# Rezoning Transportation Analysis

Petition Number: 2023-027

Date	Description
06-28-23	First Review (PDM)
07-27-23	Second Review (PDM)

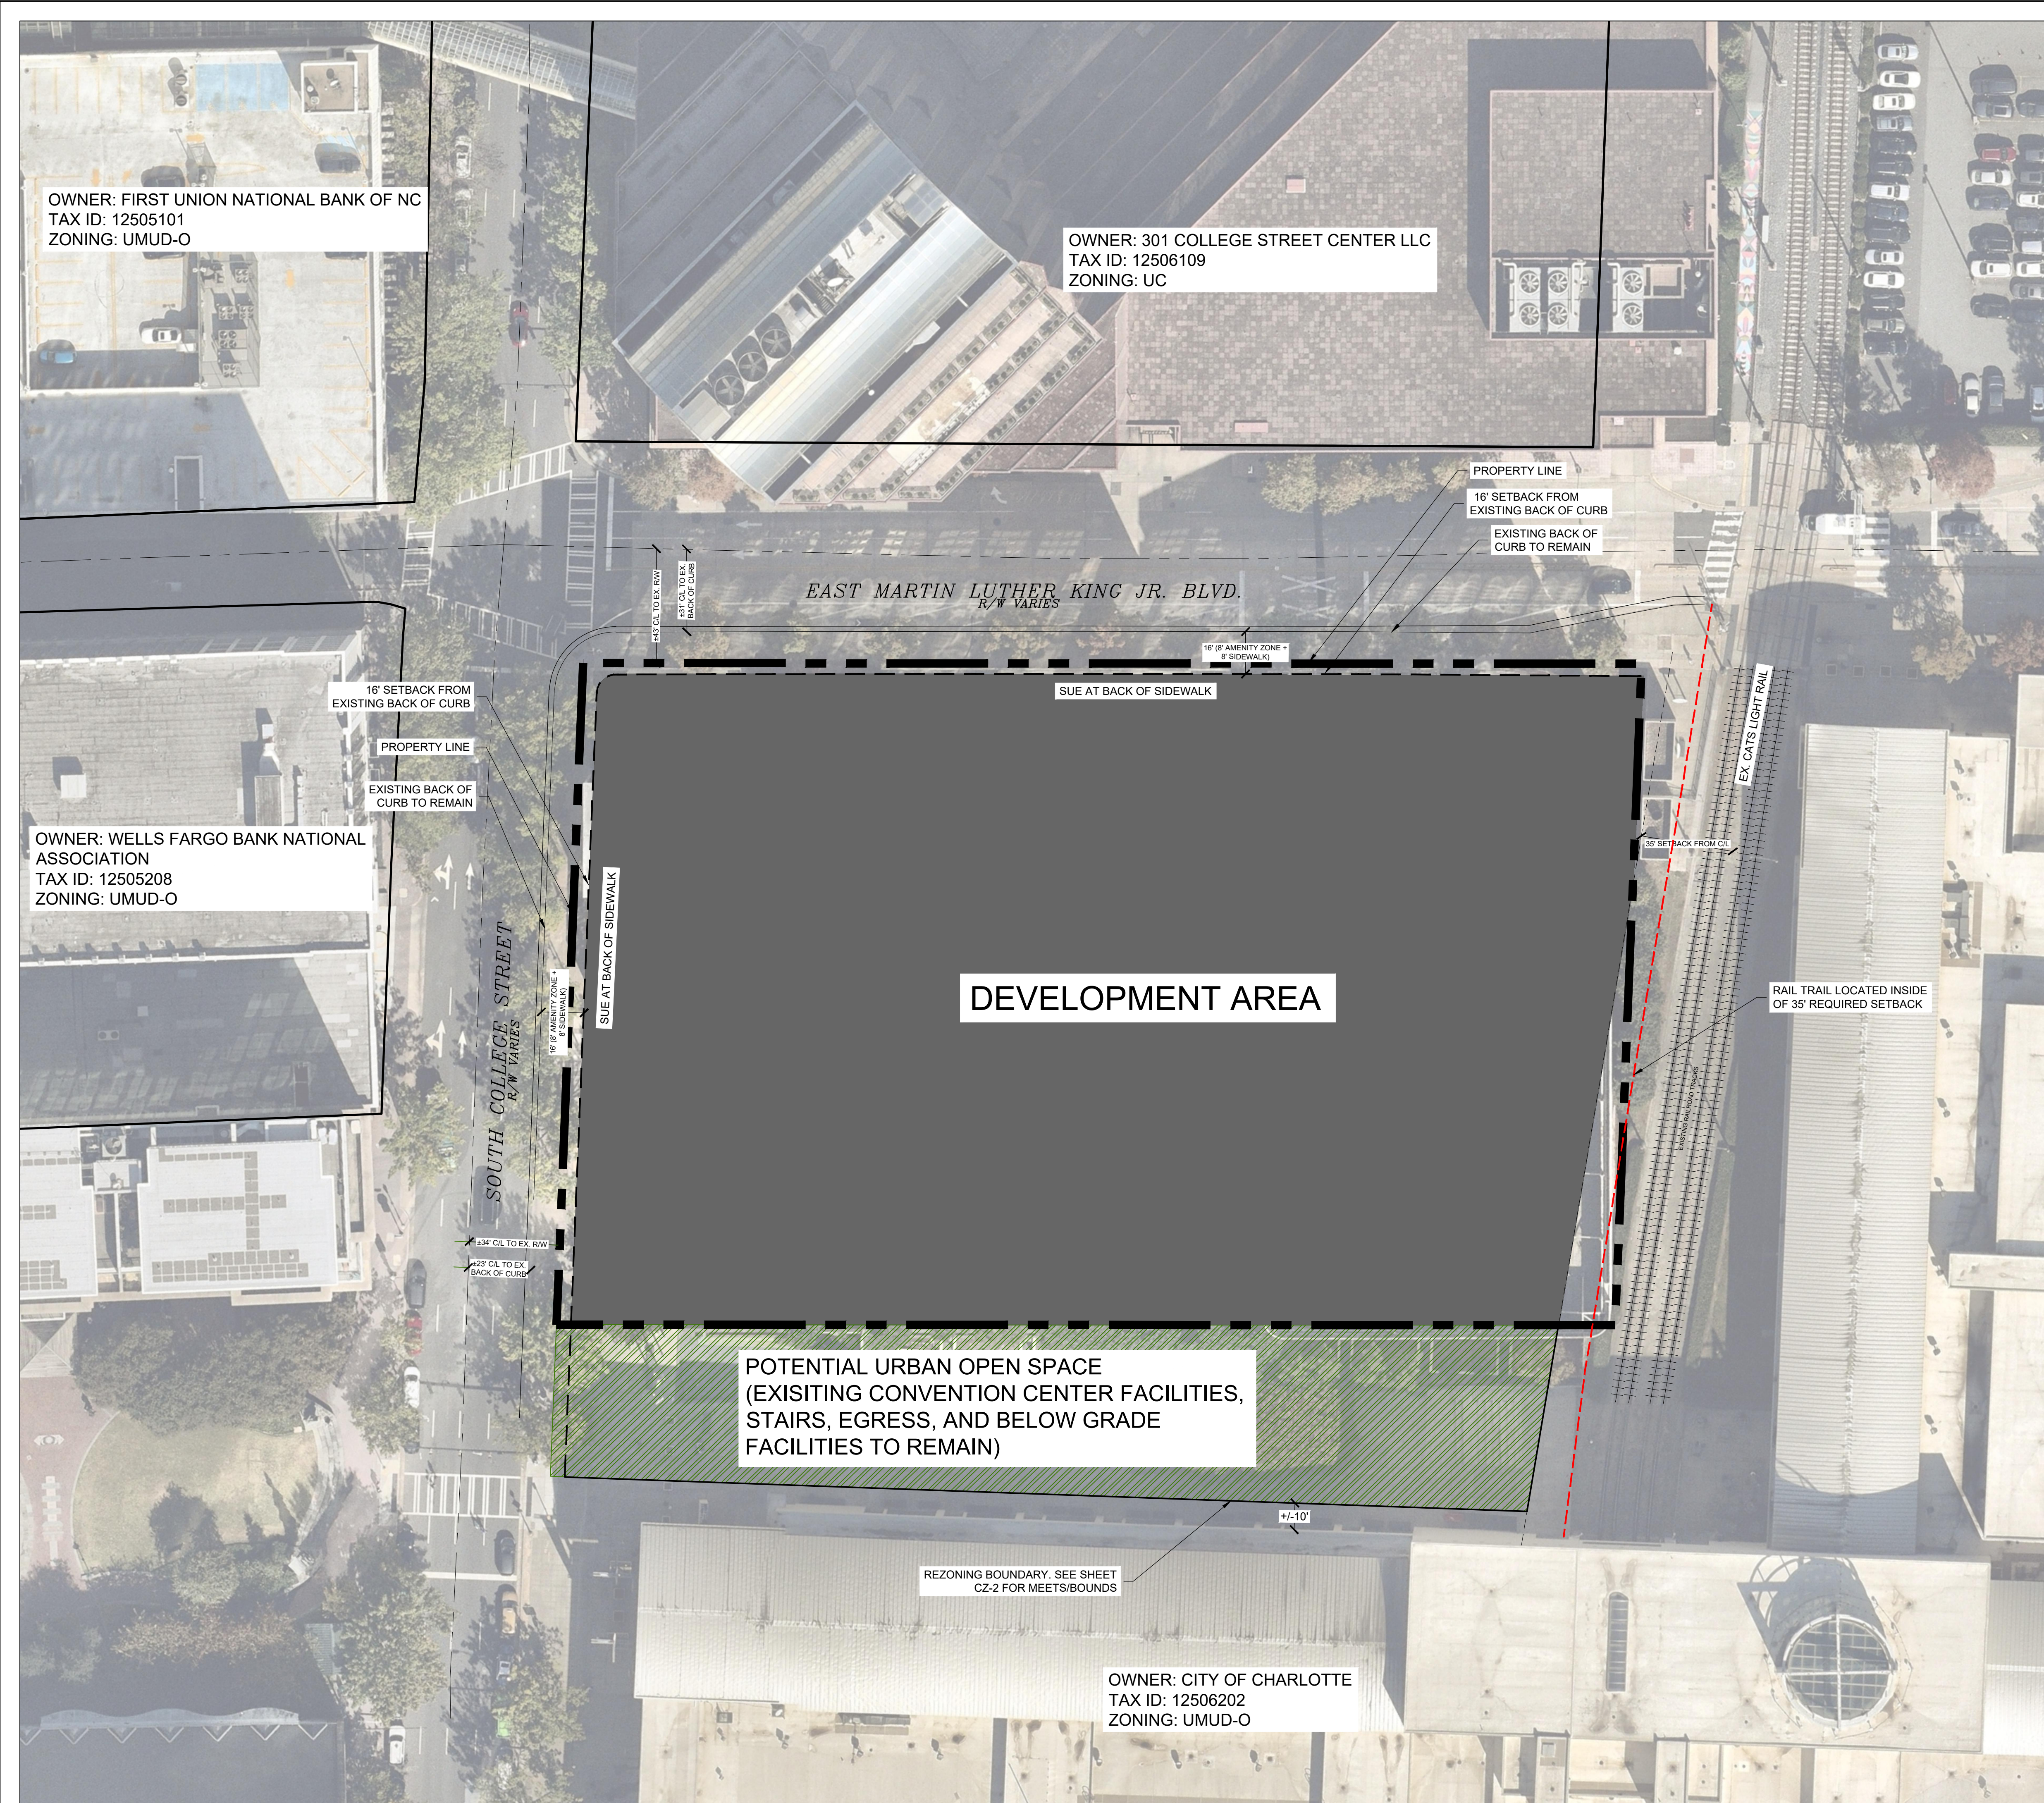
Revise site plan and conditional note(s) to commit to dedicate 40-feet of right-of-way from the road centerline on College Street. The site plan shall label and dimension the right-of-way from the road centerline. In addition label and dimension the right-of-way on Martin Luther King.

Revise site plan to show the proposed sites access locations and types.

Revise site plan to add more clarity to the area below that is outside of the property line but part of the rezoning. Is this public ROW?

Remove callout and conditional note regarding relocation by others for construction of Rail Trail. This should be coordinated during the rezoning phase of the project.

Show proposed locations of Valet Parking. Valet Parking locations should be reviewed by CDOT during the rezoning phase of the project.
